OFFICIAL NOTICE OF DECISION

CITY OF ALBUQUERQUE  
PLANNING DEPARTMENT  
DEVELOPMENT REVIEW BOARD

**Project# 1005278**

HUNT & DAVIS, PC agents for JTH WEST, LLC and the CITY OF ALBUQUERQUE request the referenced/ above actions for TRACT A, **JUAN TABO HILLS WEST** and TRACT 1-A-1, Block 7, **JUAN TABO HILLS UNIT 2**, zoned R-D and SU-1/ MAJOR PUBLIC OPEN SPACE, located on the west side of JUAN TABO BLVD SE between the TIJERAS ARROYO and POCONO RD SE, containing approximately 98.47 acres. (M-21)

SEE SHEET 2 & 3 OF 8

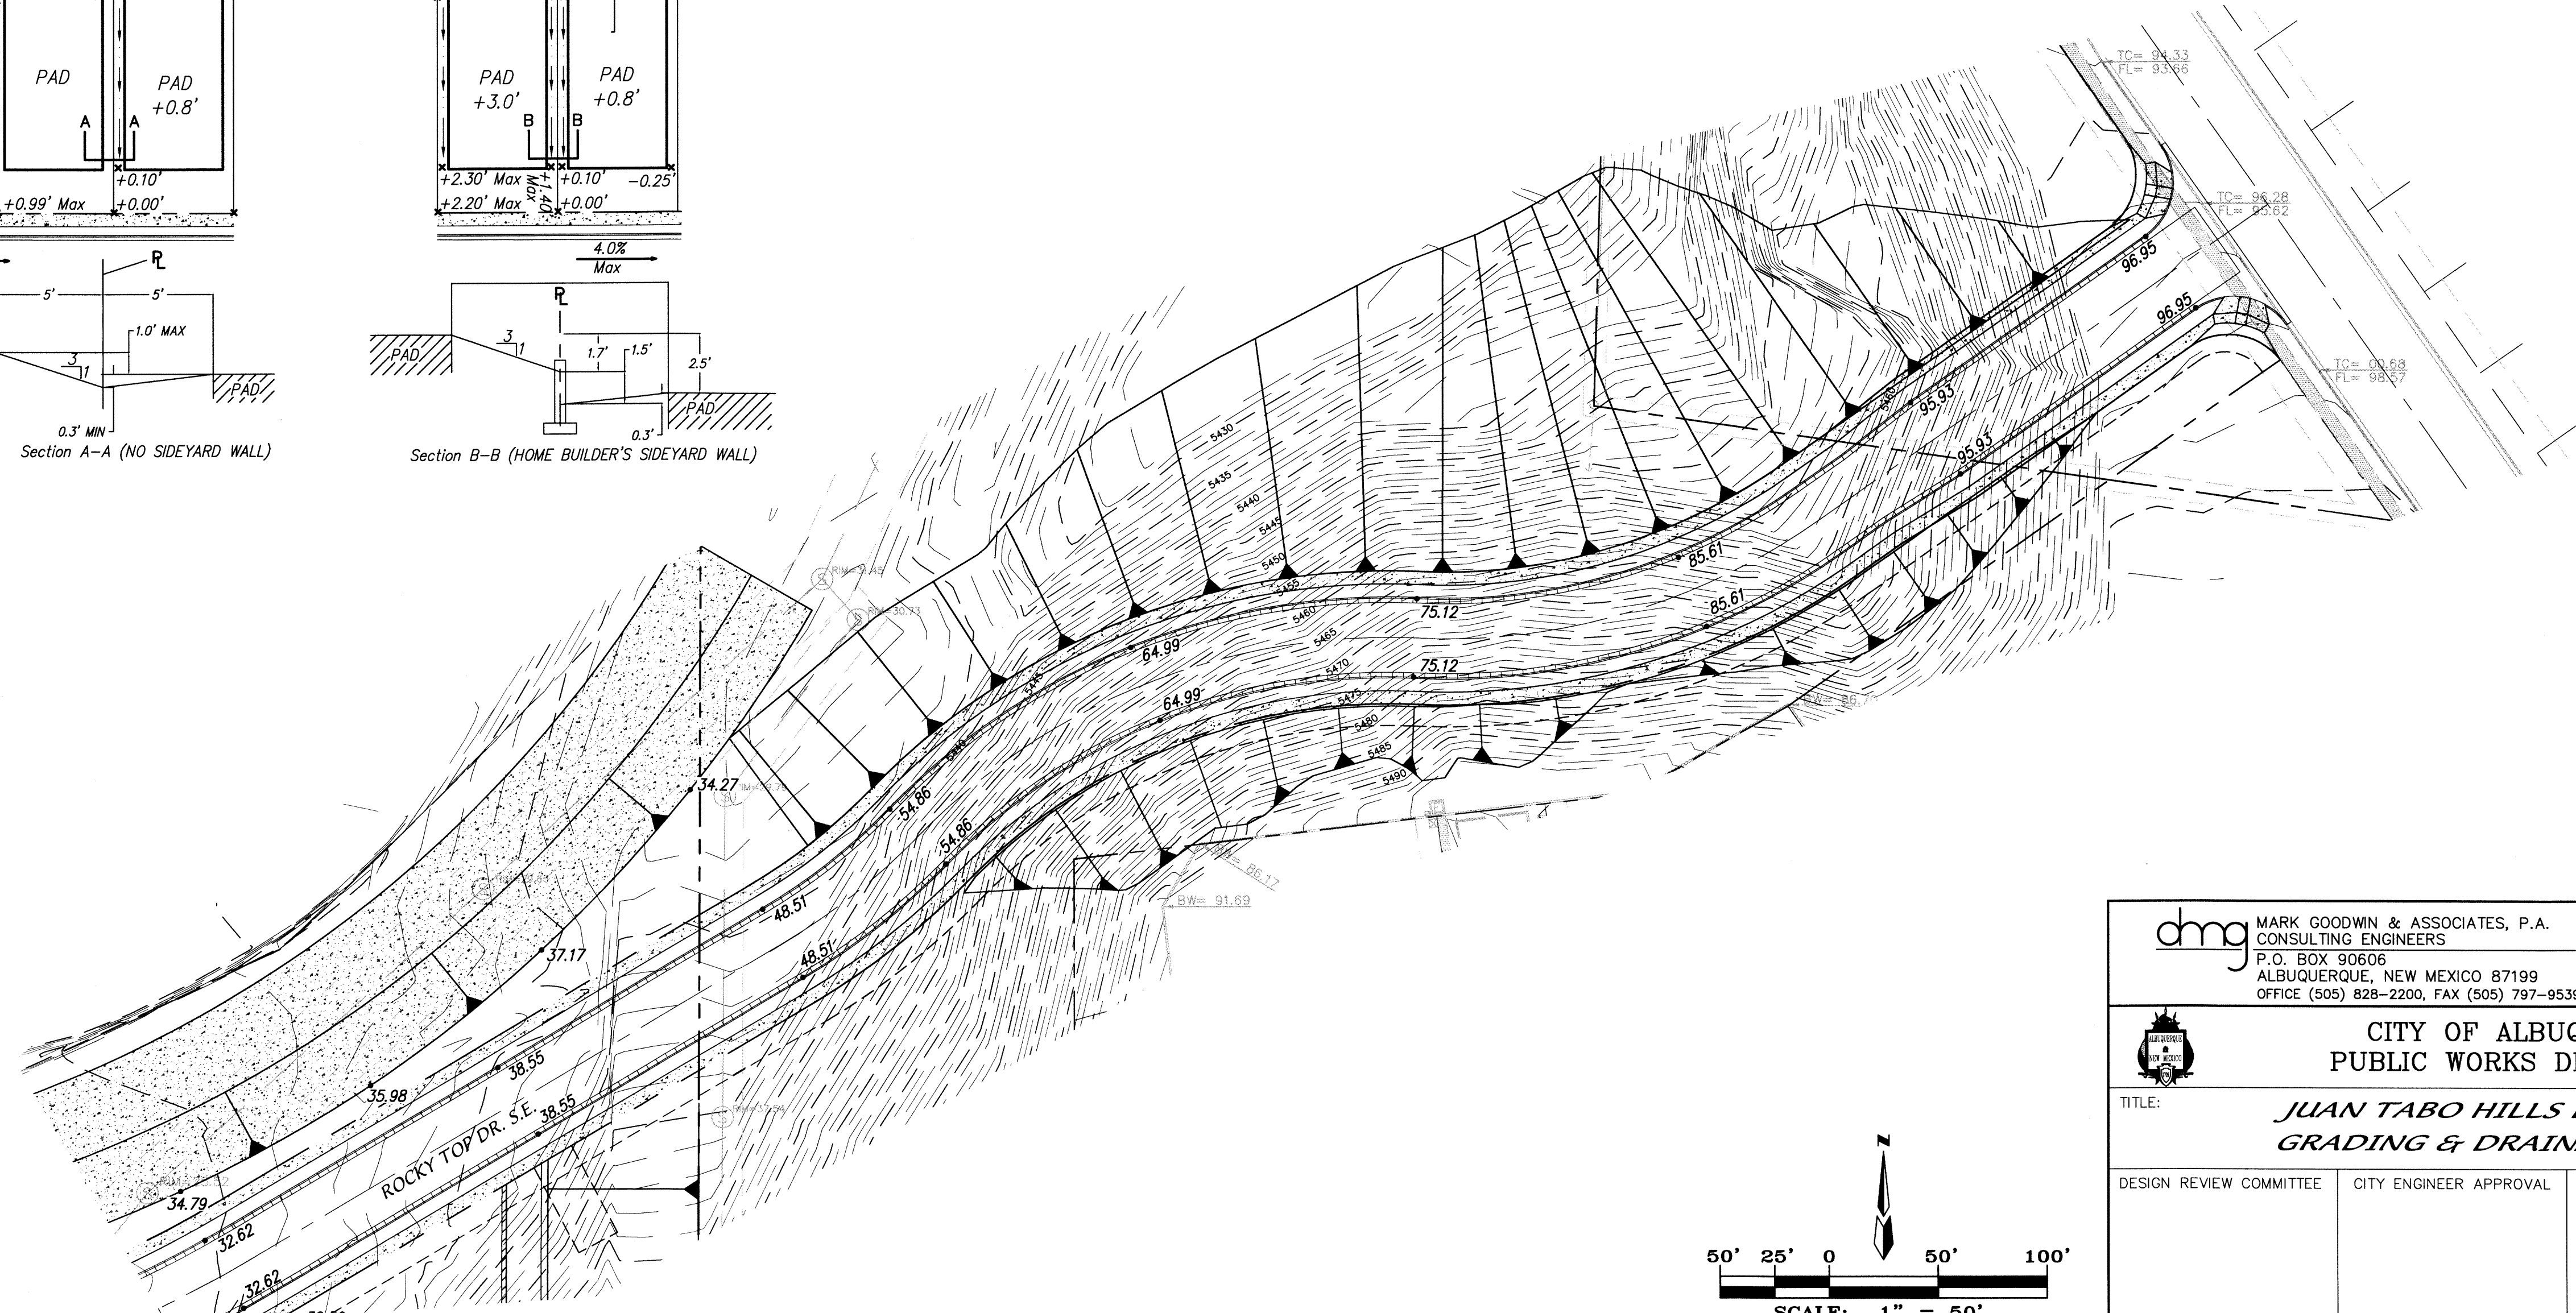
b. Proposed grading plan shows all lots to be below 5480' (within Pressure Zone 4ER).

**JUAN TABO HILLS - ESTATES
CONCEPTUAL UTILITY PLAN**

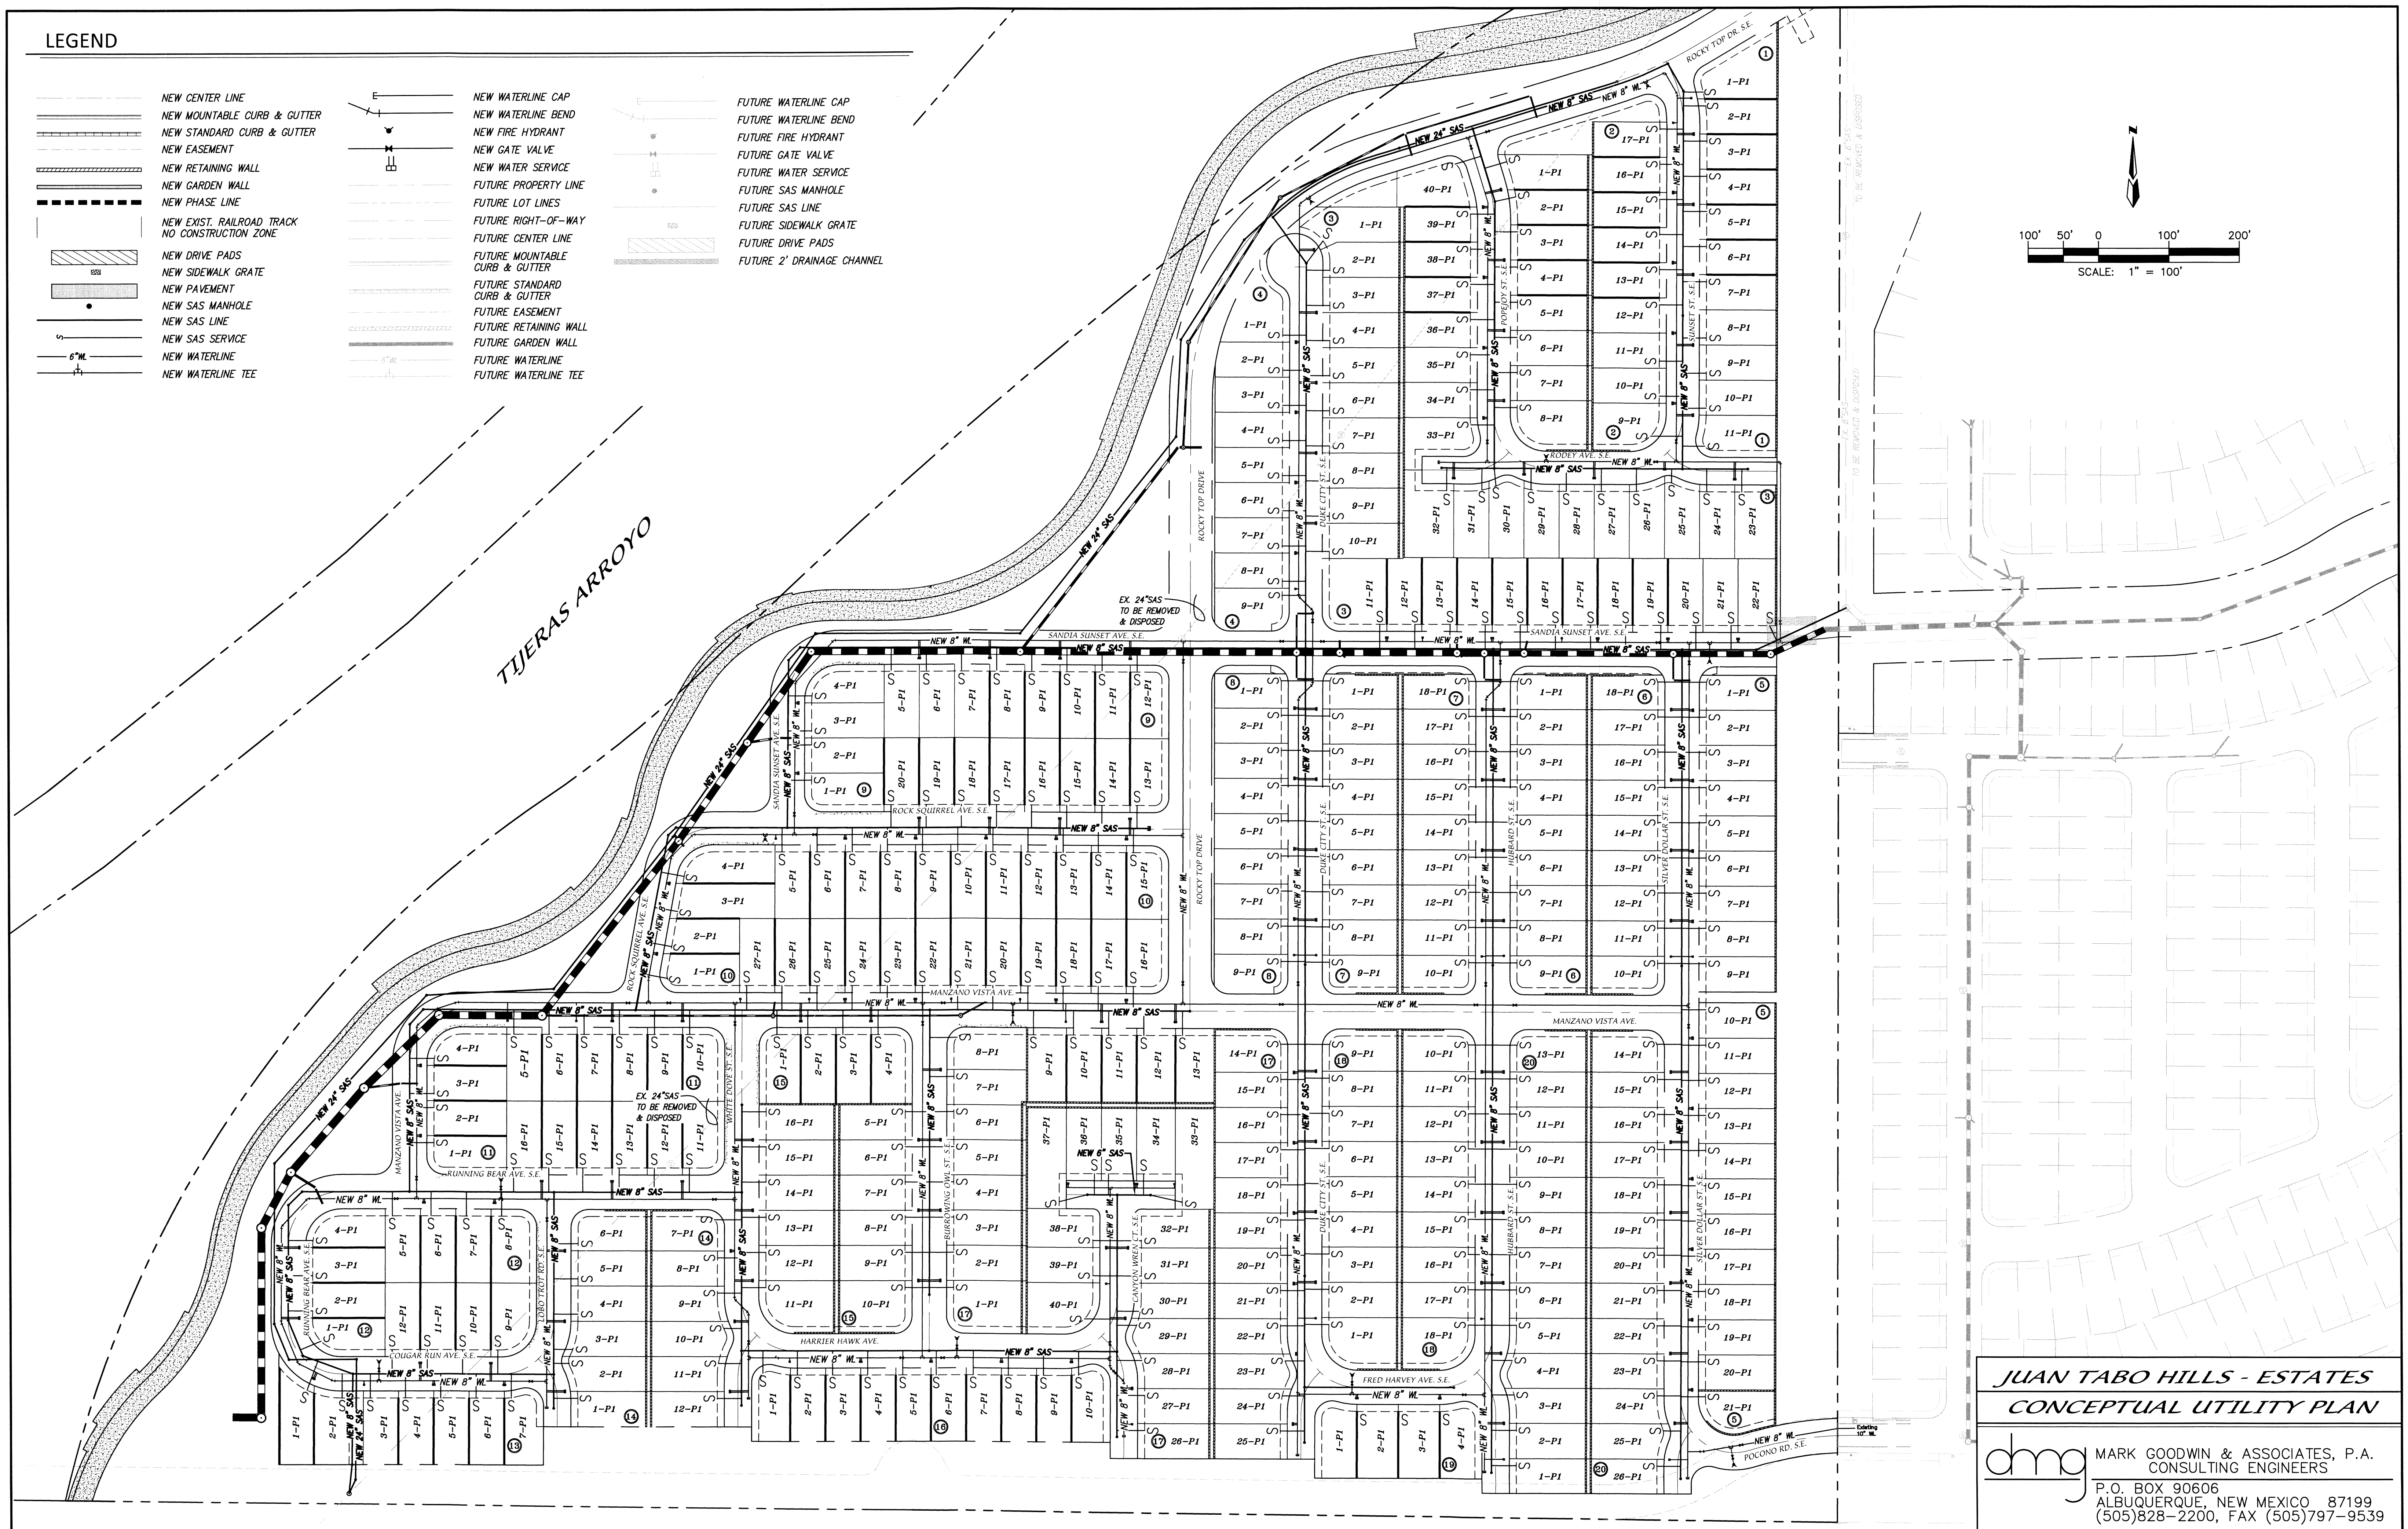
c. Utility Plan shows direct connection to 5E water lines without PRVs.

d. Show sanitary sewer lines to be removed (both 21" and 8" along east side of property)

e. Label streets and existing water and sanitary sewer in Utility Plan.

<p>8" waterline along Blue Ribbon Rd. and 8" waterline between Gallant Fox Rd. and Blue Ribbon Rd.</p> <ul style="list-style-type: none"> <li>iii. Infrastructure List states 6" waterline along Hubbard St. from Fred Harvey Ave to Lot 1 Block 20 and Utility Plan shows 8".</li> <li>iv. 6" waterline along Canyon Wren Ct. from North End of Cul-de-sac to Lot 26 Block 17 is shown as 8" waterline on Utility Plan. Plan shows 6" waterline along the hammerhead only.</li> <li>v. General comment: Areas where a proposed 6" waterline serves less than 8 lots can be served with a 4" waterline instead if fire hydrants are not being served from said line.</li> <li>vi. 6" waterline along White Dove St. from Harrier Hawk Ave. to Manzano Vista Ave. is shown as an 8" on the Utility Plan.</li> <li>vii. Include removal of existing 21" sanitary sewer interceptor.</li> <li>viii. Include removal of 8" collector located east of the project location that runs north/south.</li> </ul> <p>5. Preliminary Plat</p> <ul style="list-style-type: none"> <li>a. Easement D (existing 20' sanitary sewer easement) along east property line needs to be vacated as this line will be removed.</li> </ul>
